## SPR EA1N and EA2 PROJECTS

### DEADLINE 11 – RESPONSES TO APPLICANTS D10 COMMENTS ON SASES D9 SUBMISSIONS

Interested Party: SASES      PINS Refs: 20024106 & 20024110

Date: 7 June 2021      Issue: 1

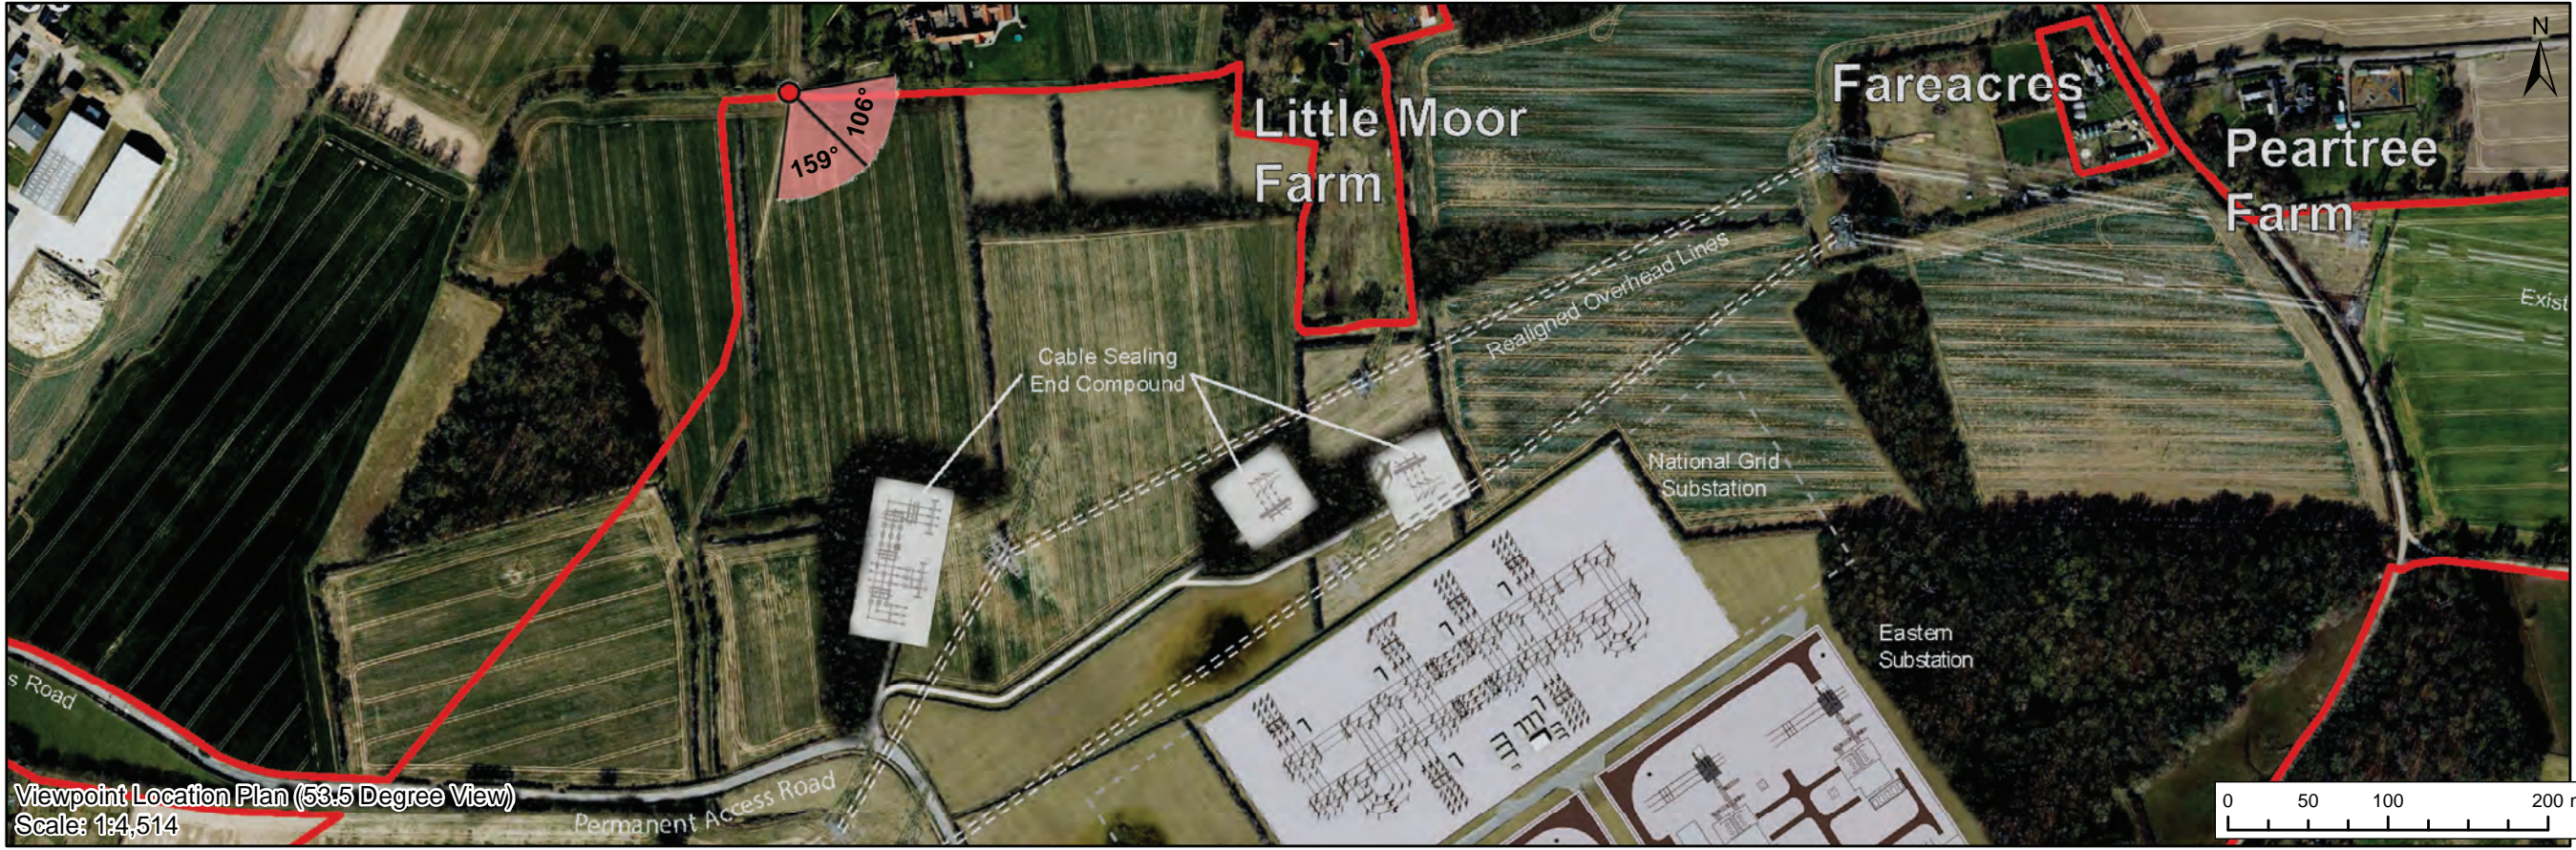
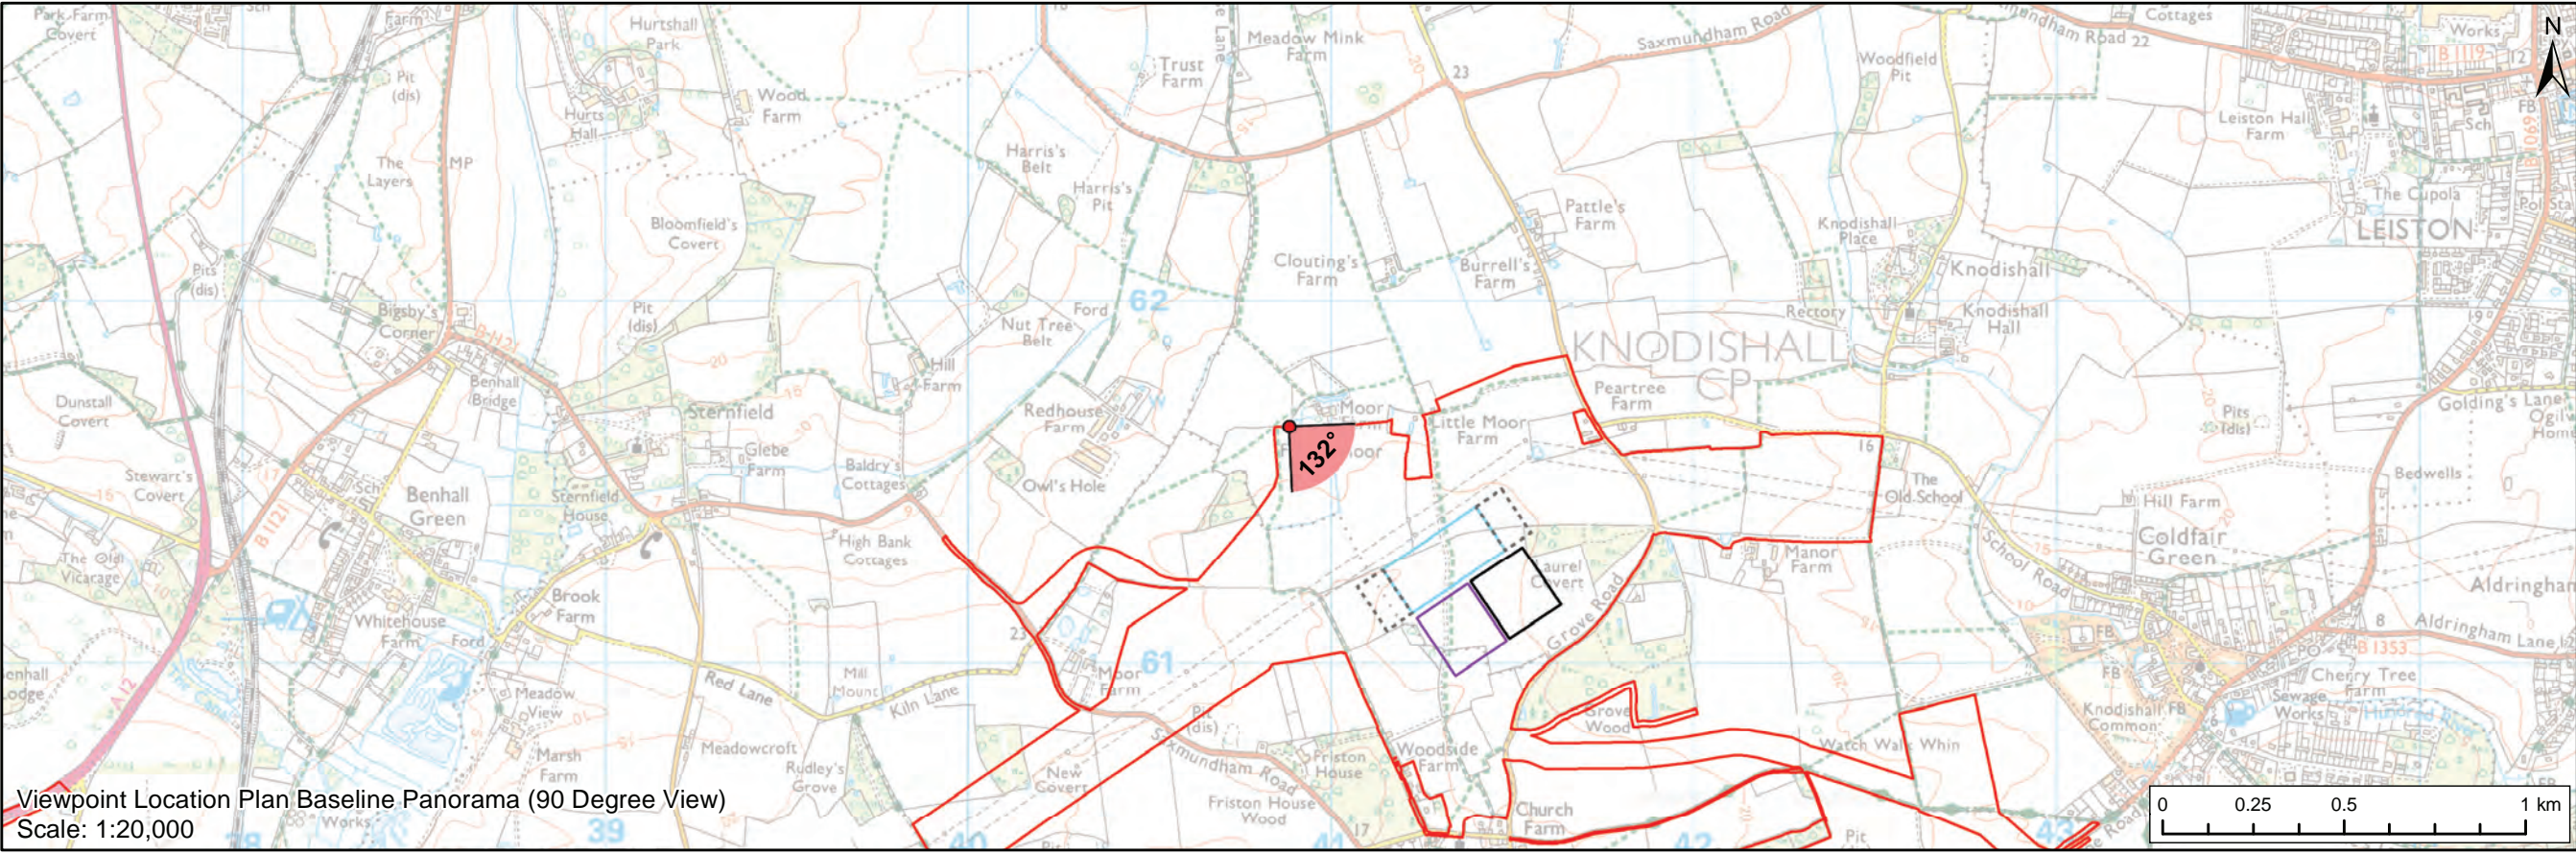
**ID37** – the Applicants have referred to the Photomontages with Potential National Grid Extensions Bays (REP8 - 071 – REP8–073). In considering these together with the drawings attached to the Design and Layout of the Substation (Additional Submission - EA1N&EA2 Applicants’ Response to Rule 17 Questions of 13 May) prepared by the Applicants dated 21 May 2021, there are omissions and errors in both in a key photomontage and the drawings relating to the representation of the pylons and cable sealing ends. Further details are set out in SASES’ Deadline 11 submission, Comments on the Drawings in the Design and Layout of the Substations. SASES has previously raised concerns about the accuracy of the photomontages which the Applicants have denied.
